FROM: Ian Gledhill **TO:** Arun District Council
FAO: Ross Leal

SUBJECT: FG/183/17/PL - Change of use of land from permitted B8 storage use & erection of new detached office building (Use Class B1) with access via Hangleton Lane & associated car parking, cycle storage & refuse storage.

Land adj to The Barn, Hangleton Lane, Ferring, West Sussex

DRAWING TITLE
Proposed site plan,
Block plan and Location Plan

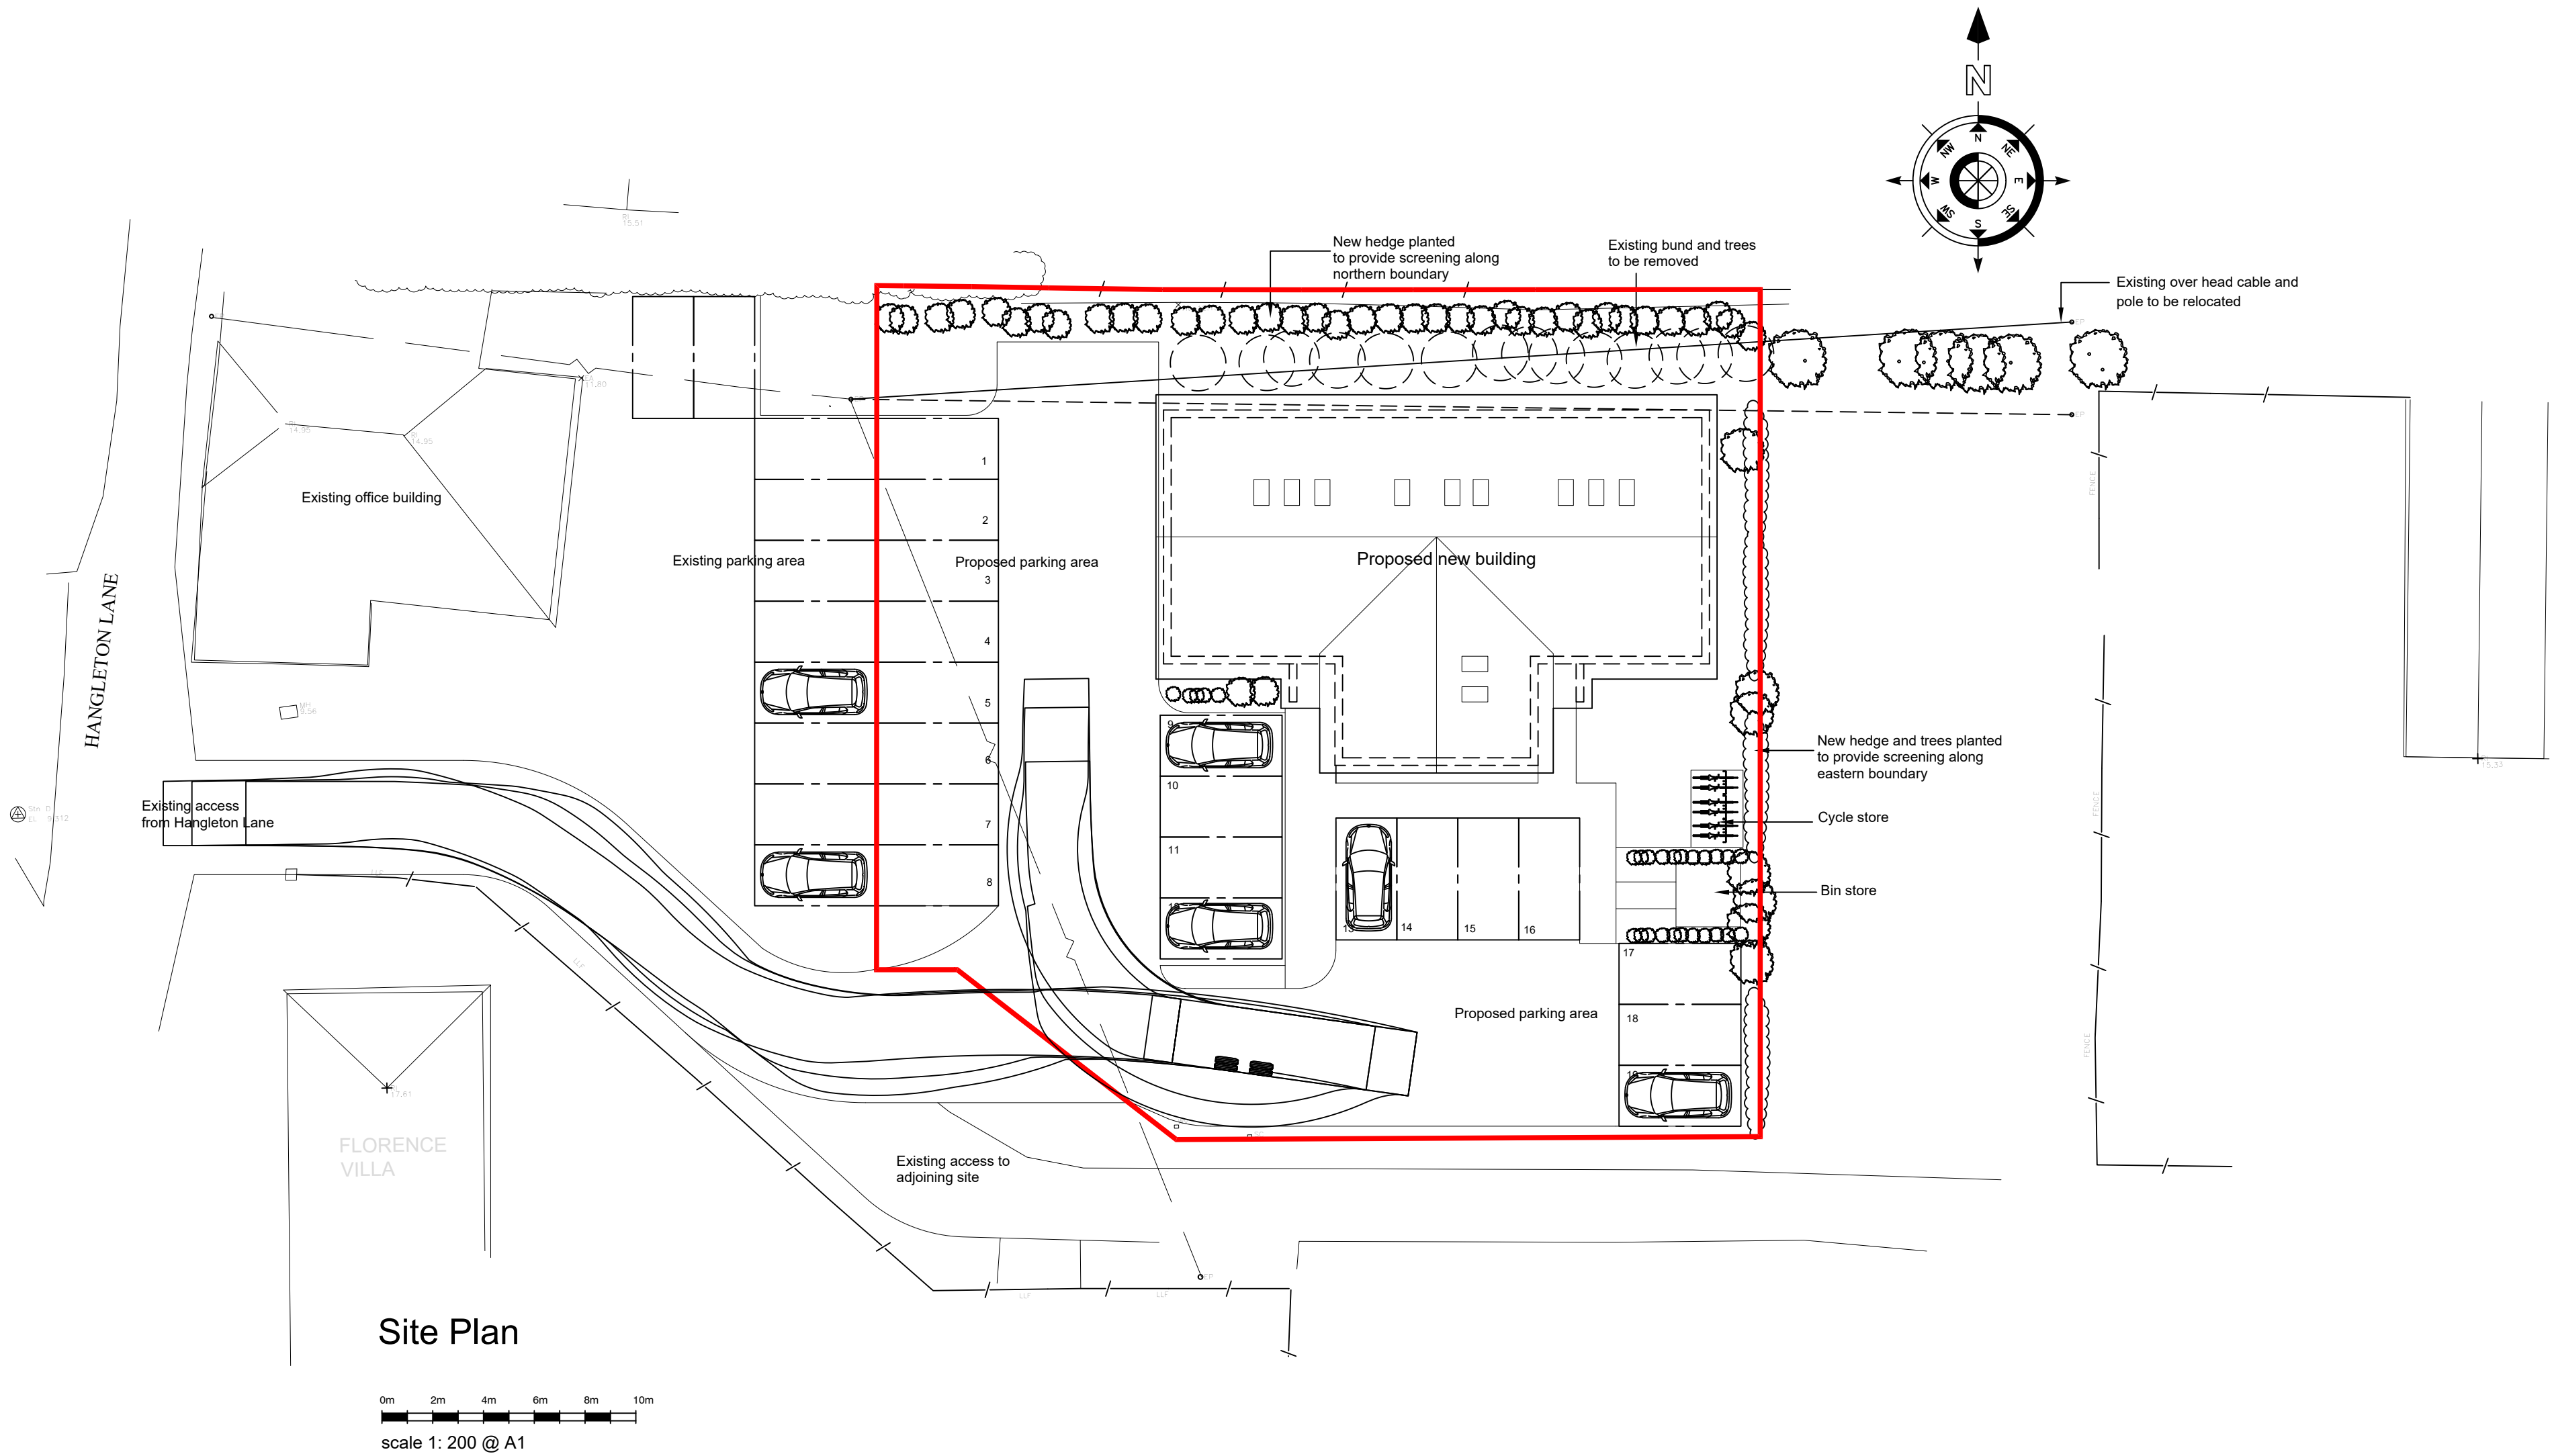
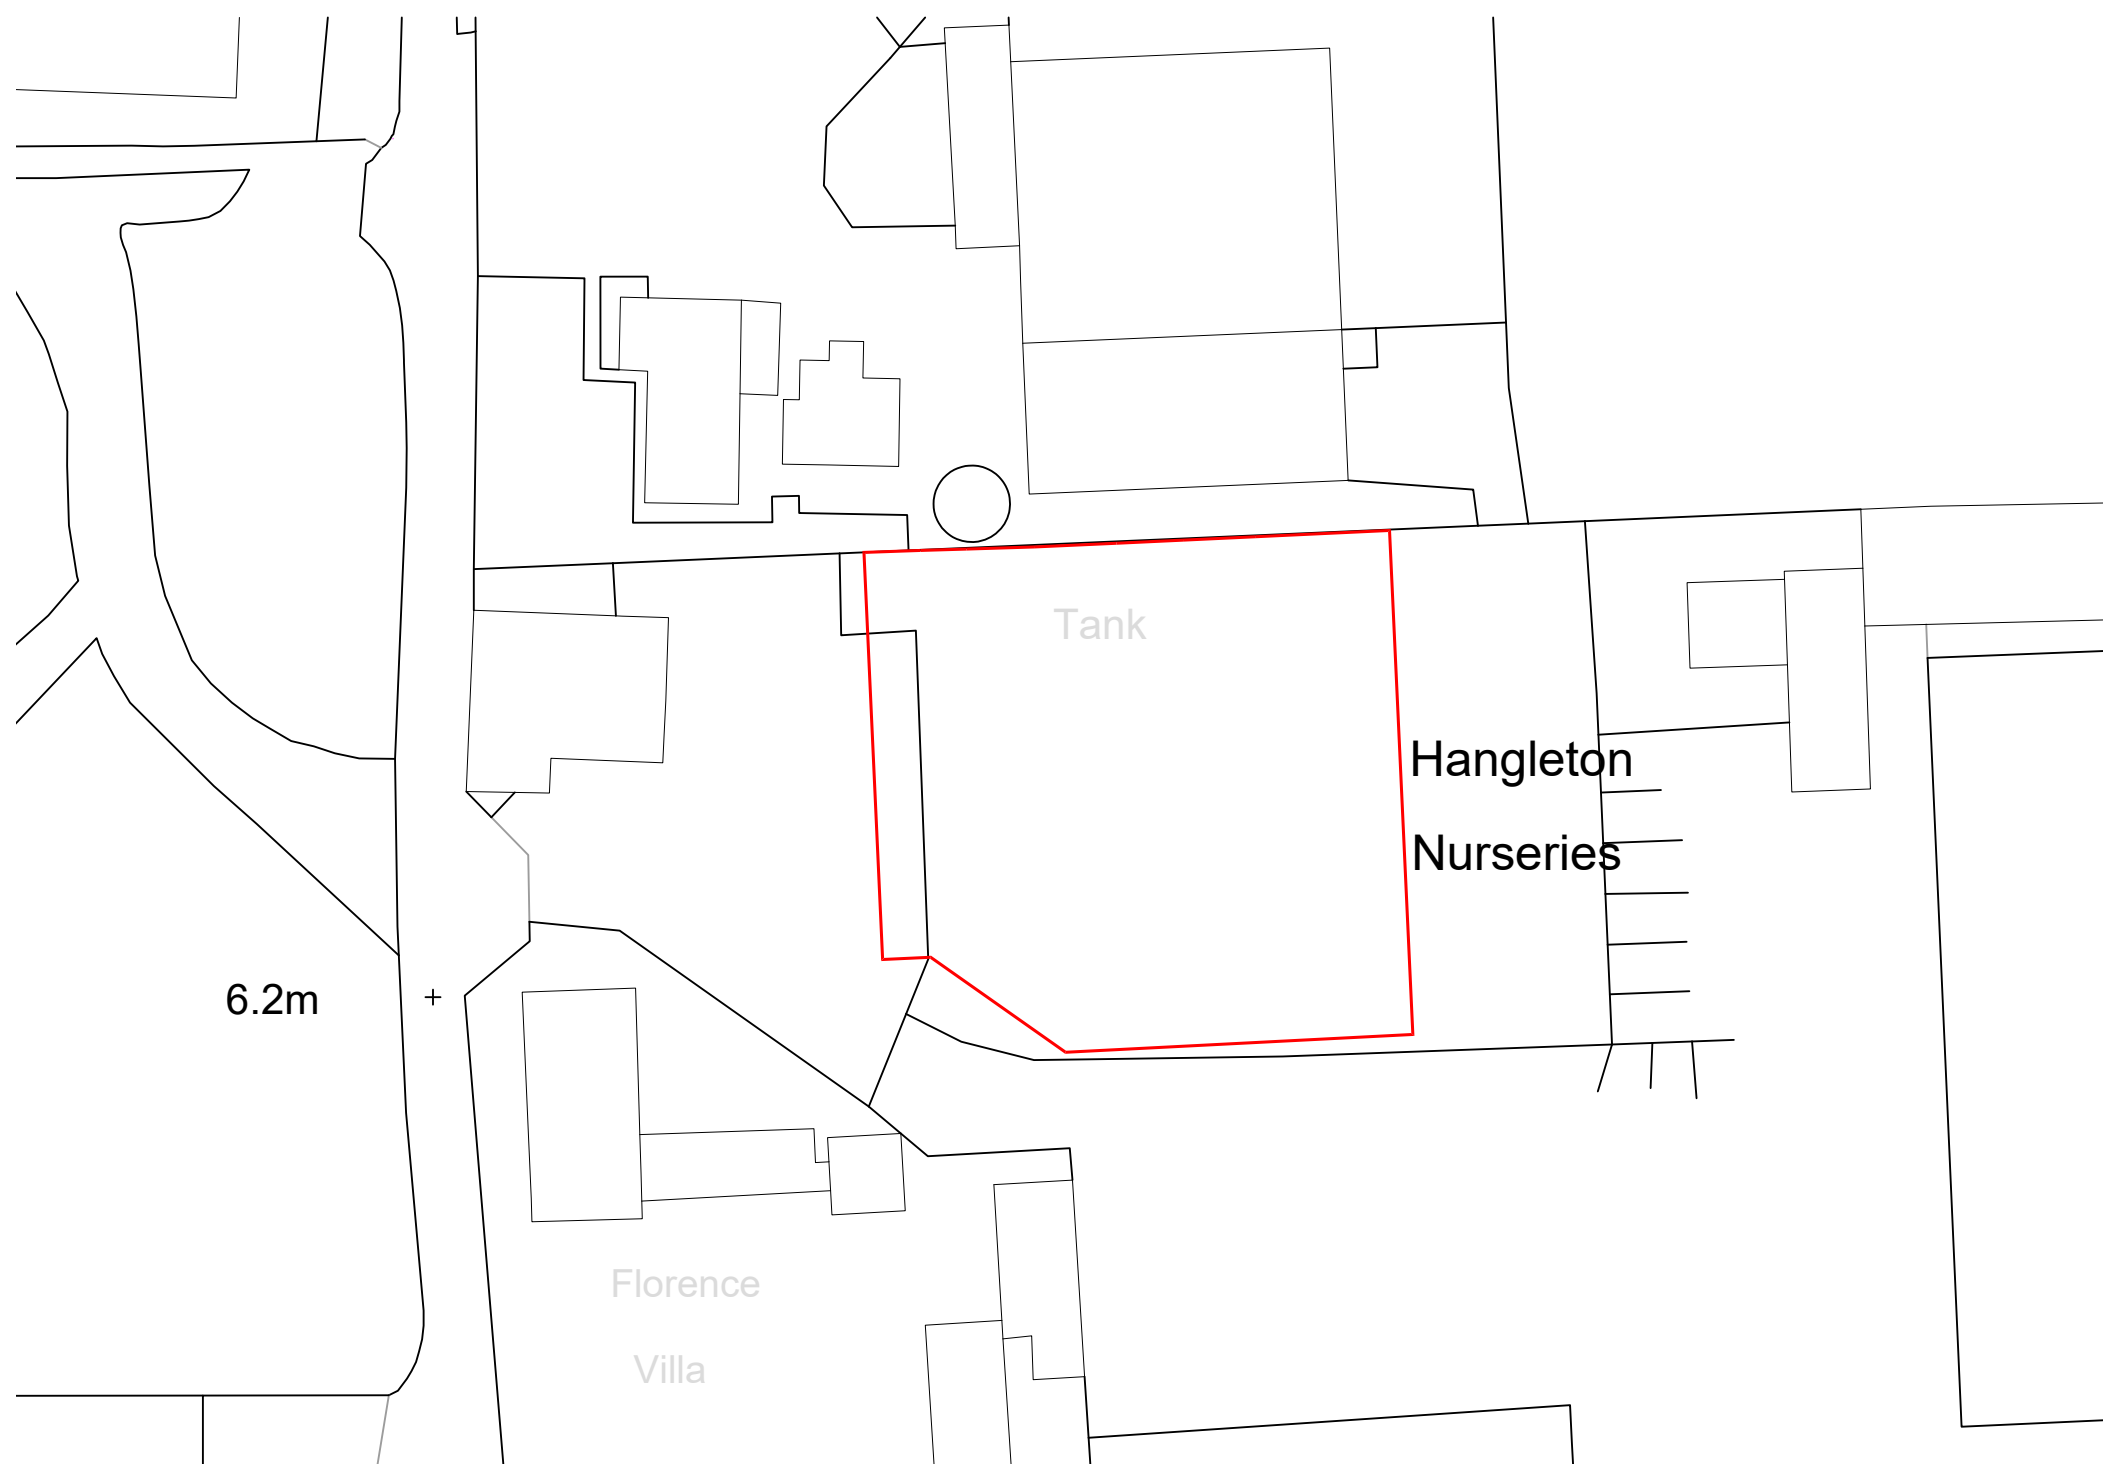
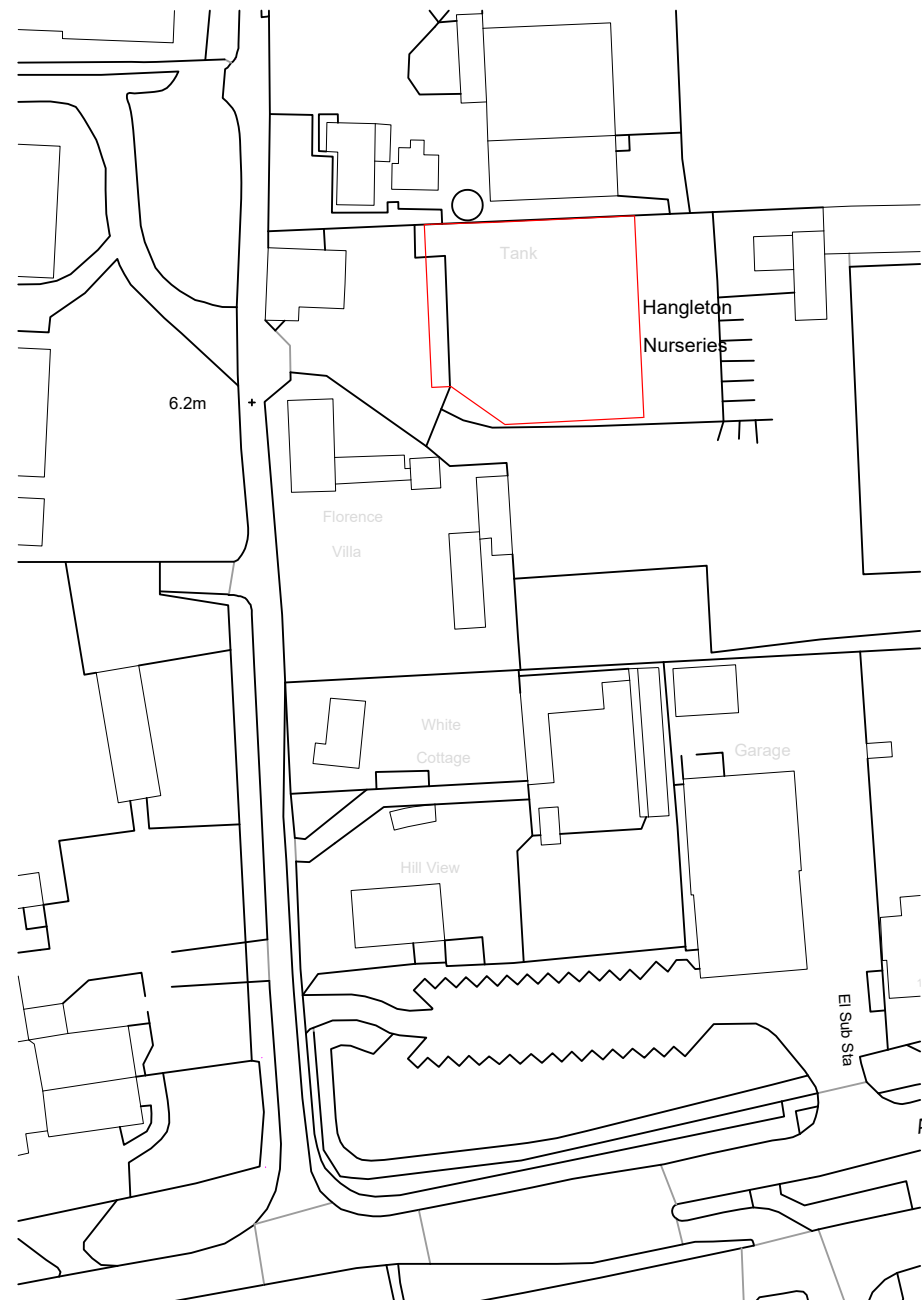
Access is to be taken via Hangleton Lane although it is noted that the access and access road leading to the site falls outside of the application red edging. It is accepted that the access has been in use in association with other permitted uses for some time. The proposal is though anticipated to intensify the use of this. On this basis, details would be sought demonstrating that the access complies with current standards and is suitable to accommodate the additional activity.

Parking provision has been reviewed against the WSCC Parking Standards. A slight over provision is included, this is understood to be for operational purposes and to meet peak demands arising from staff. Some of the parking is shown as tandem spaces. This approach is considered acceptable as the spaces are to be used only be staff associated with the building.

Consideration is given within the TS towards accessibility by sustainable modes. It's accepted that the site lies within reasonable walking and cycling distance, along with there being access to bus services that operate on the A259 corridor. There are however very limited provisions for walking or cycling along Hangleton Lane. Whilst no specific provisions would be required for cyclists, for pedestrians there are no footways nor is the lane lit. This is recognised as an existing situation but it would be helpful to understand how many additional pedestrian movements are expected as a consequence of this proposal.

Further information would be sought to address the above matters regarding the vehicular access and access for pedestrians.
